Northern Beaches Hospital SSI Application SSI 13_5982

Submissions Report/Preferred Infrastructure Report

February 2014

Sunday July 7, 2013

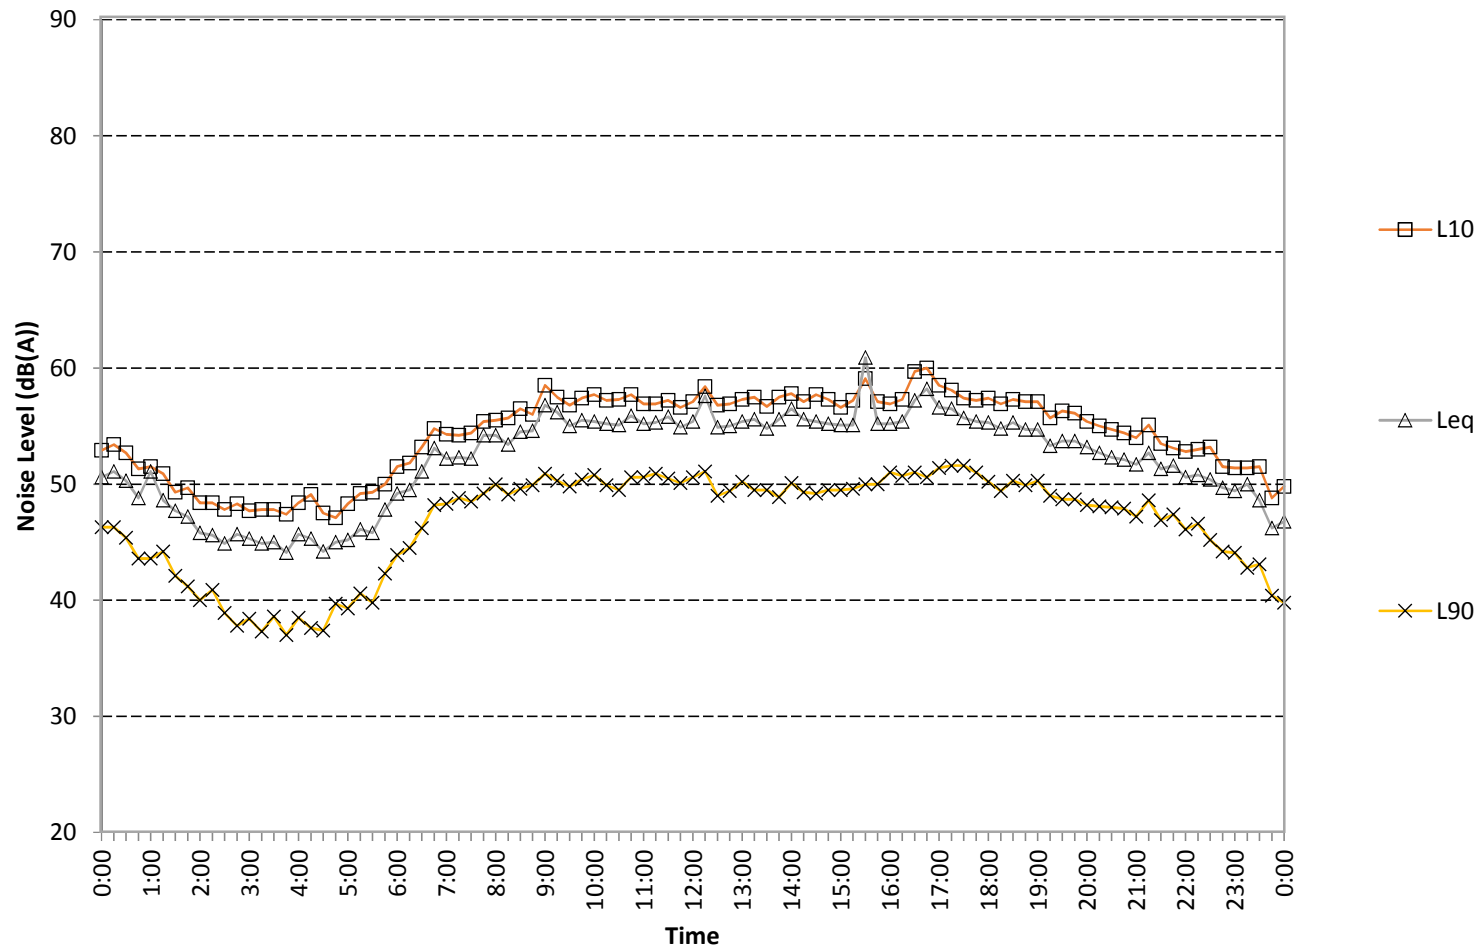
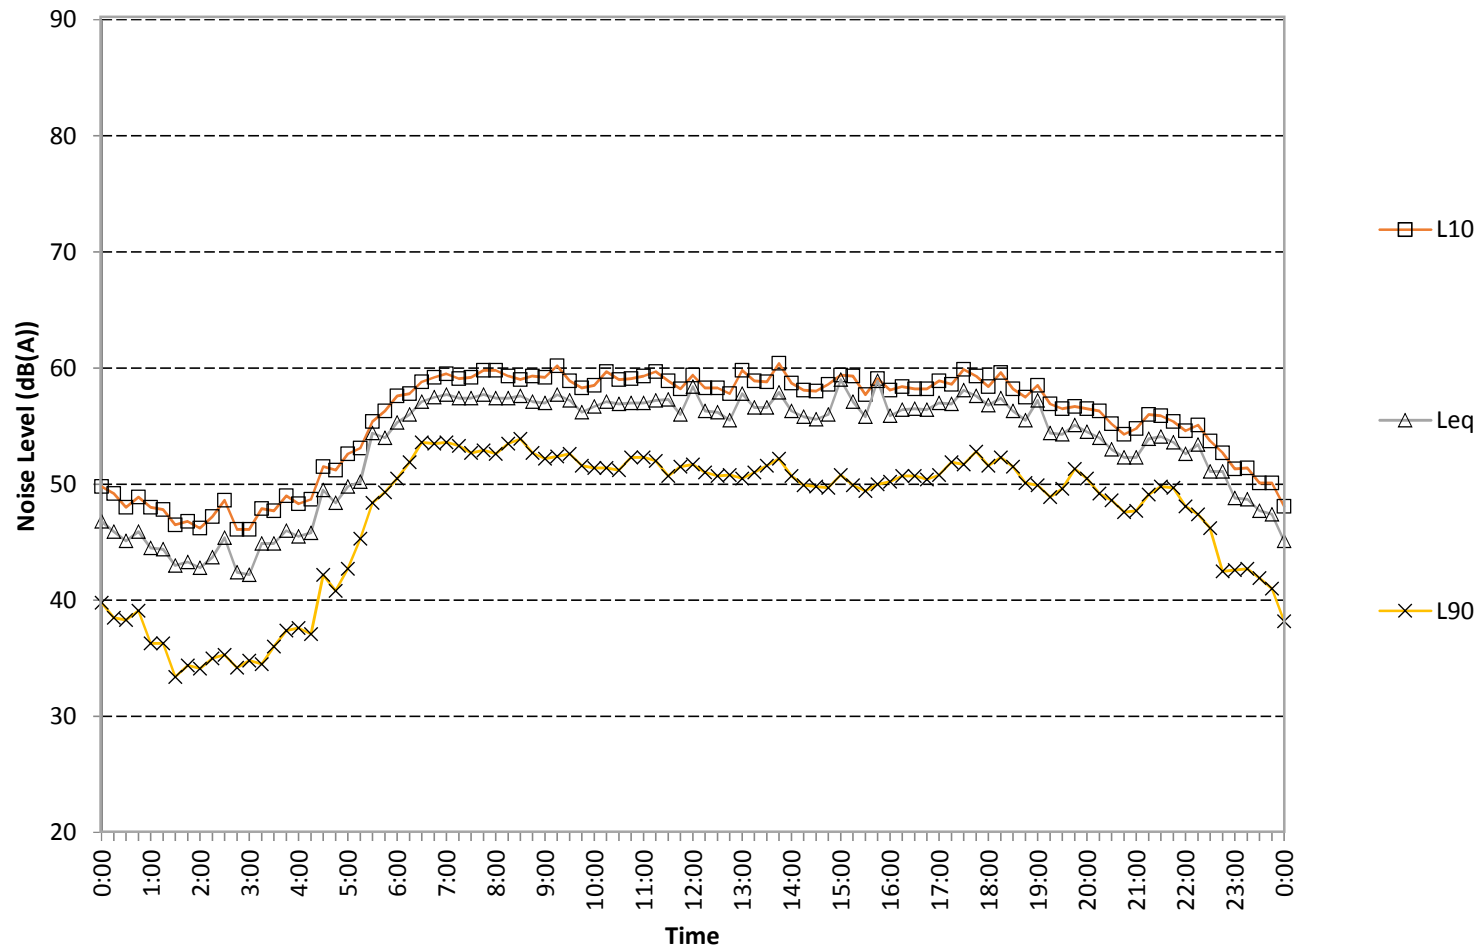
25. Background noise levels in Table 1 in Appendix K.	<p>There is a transposition error in the table. The noise levels for logger A should be against logger B and vice versa. There is a similar transposition error in Table 2 with respect to the noise-affected levels for residences on Frenchs Forest Road West and Warringah Road.</p> <p>These transposition errors have not affected the analysis, nor the conclusions drawn.</p> <p>Amended versions of these two tables are provided in Section 3.3 of this report. Background noise levels and noise criteria for periods outside of the recommended standard construction hours have also been included for completeness.</p>
